OFFICIAL NOTIFICATION OF DECISION

Project# PR-2021-005746 Application# SI-2021-001661 SITE PLAN

AS101

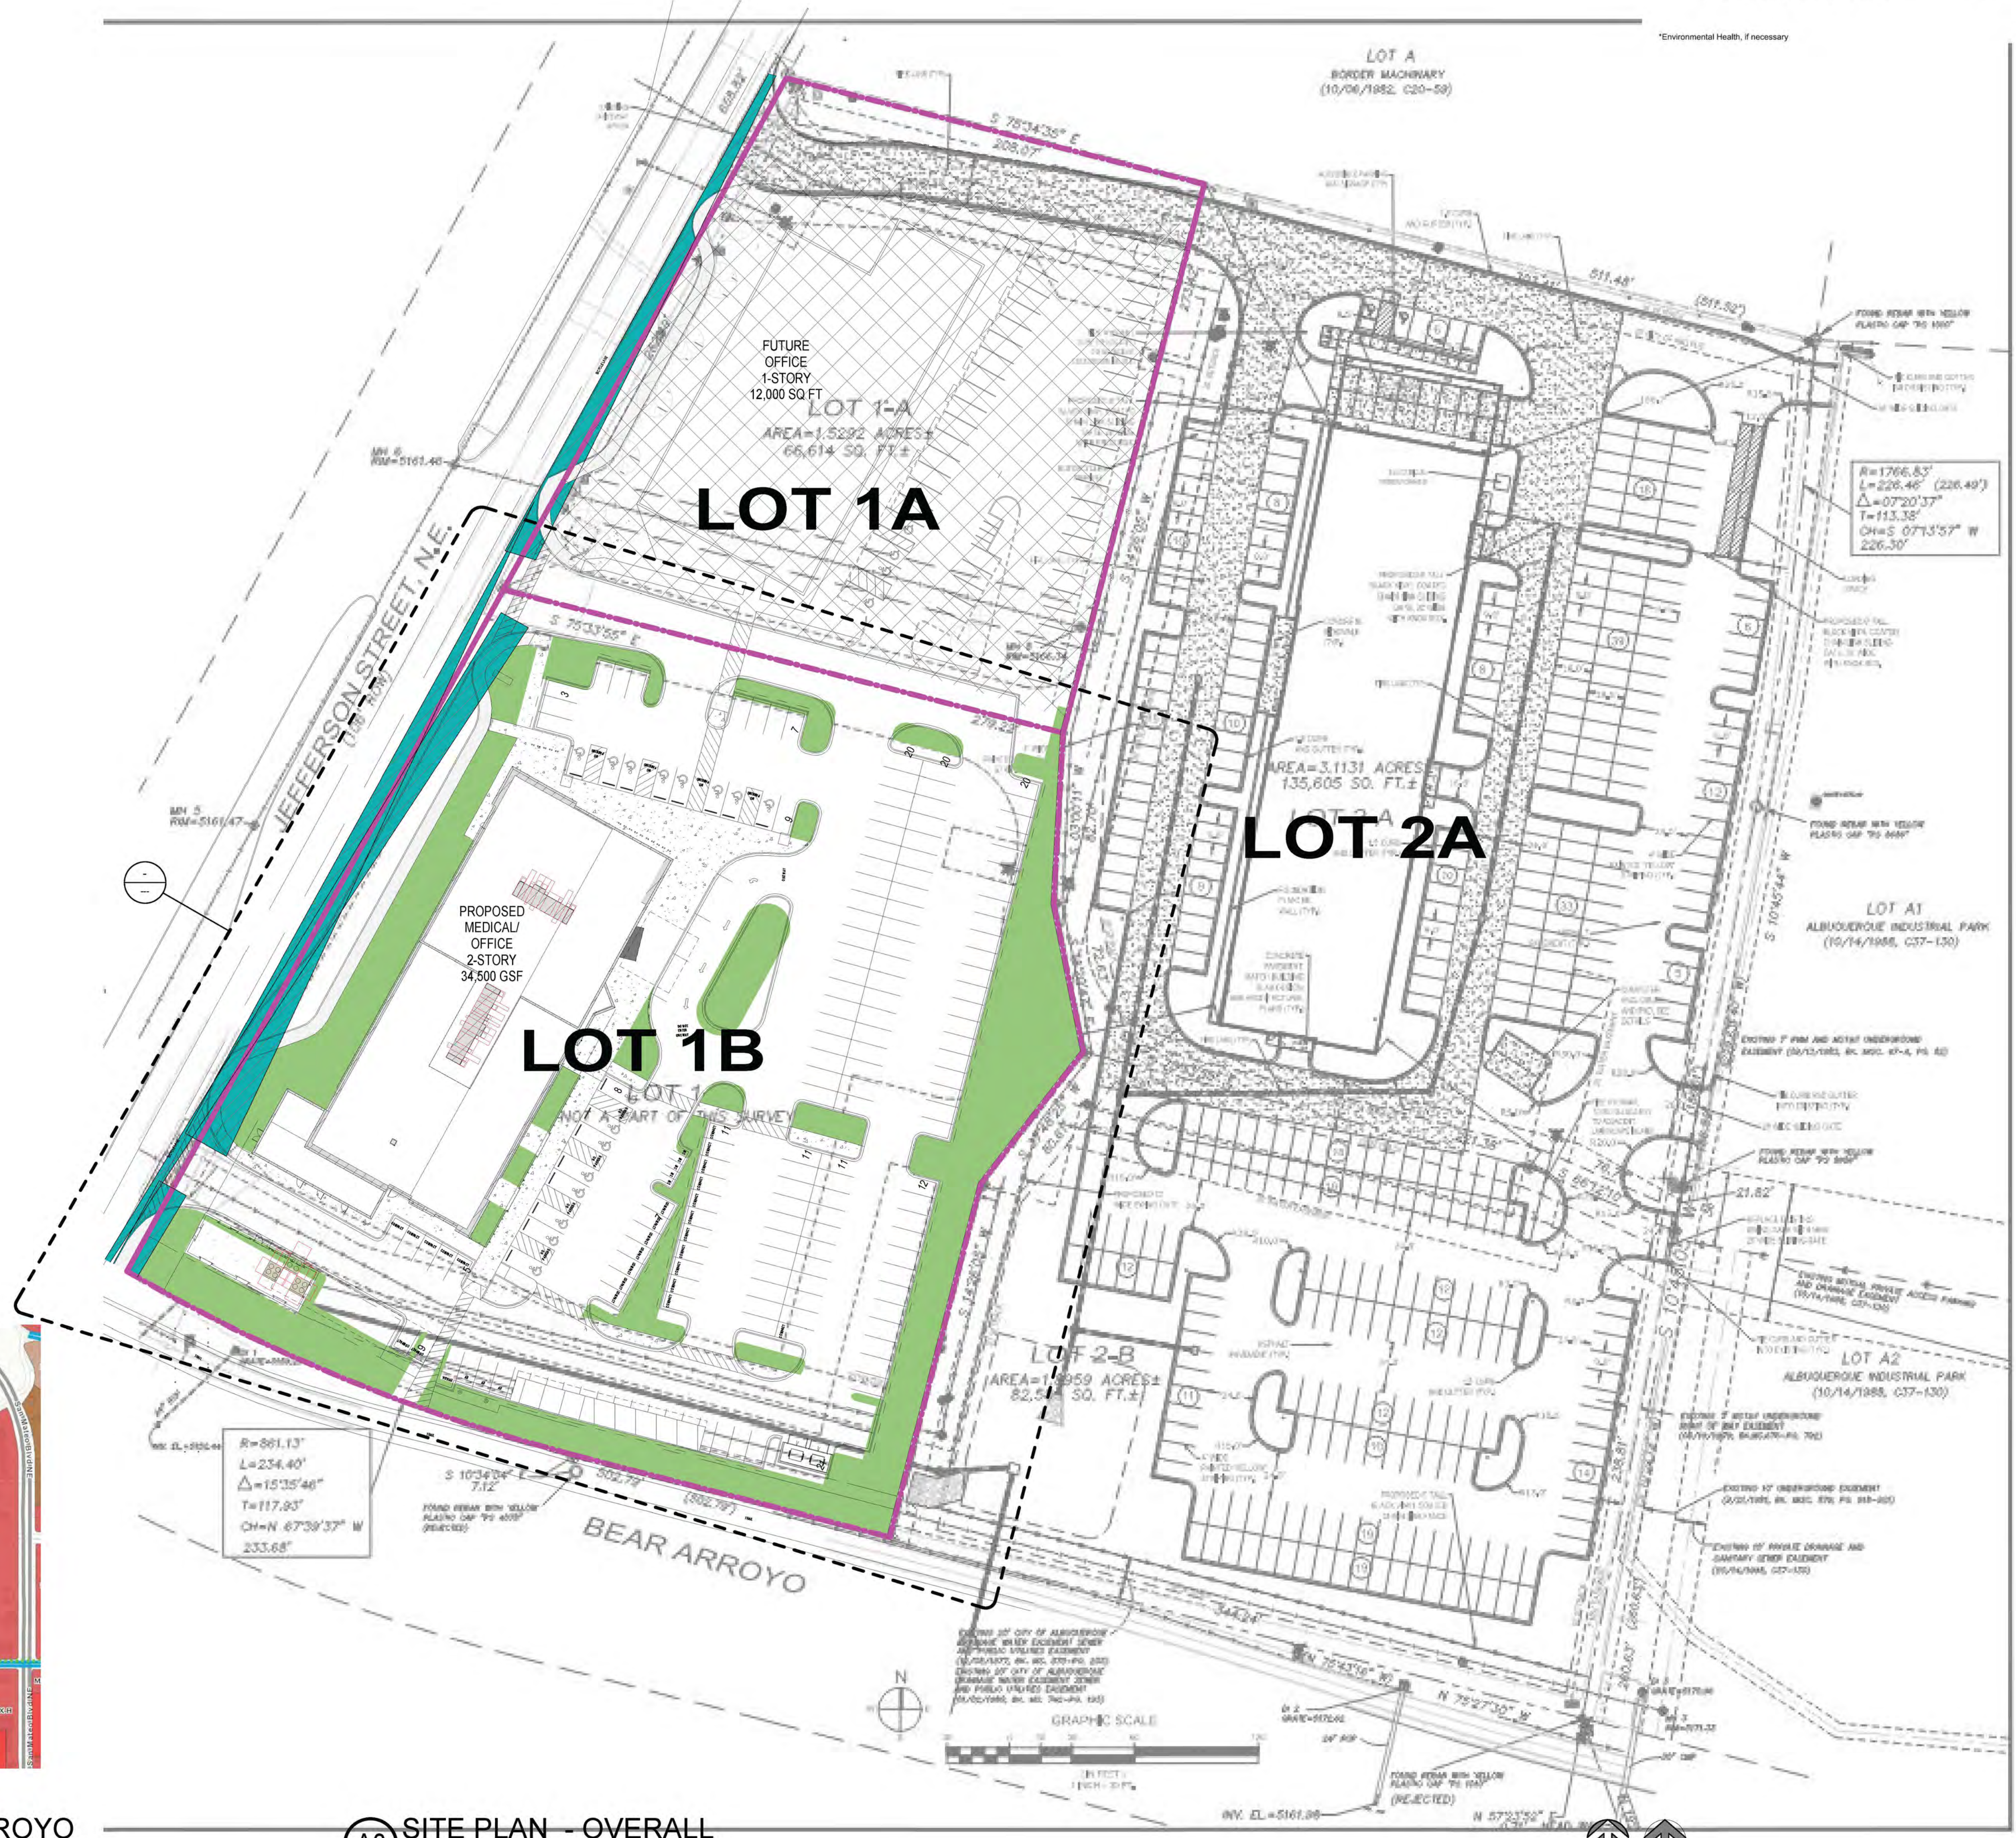
- 3. Final sign off is delegated to Planning to check for adjustment of clear site triangles and bike rack detail and to check on updates to the site plan regarding parking space requirements, minor signage, ramps and clarification of the landscape island curb radii, for the redesign of plant material along the sewer easement and alternative landscaping plan if needed, stabilization for the storm water quality pond, and the recorded infrastructure improvents agreement.
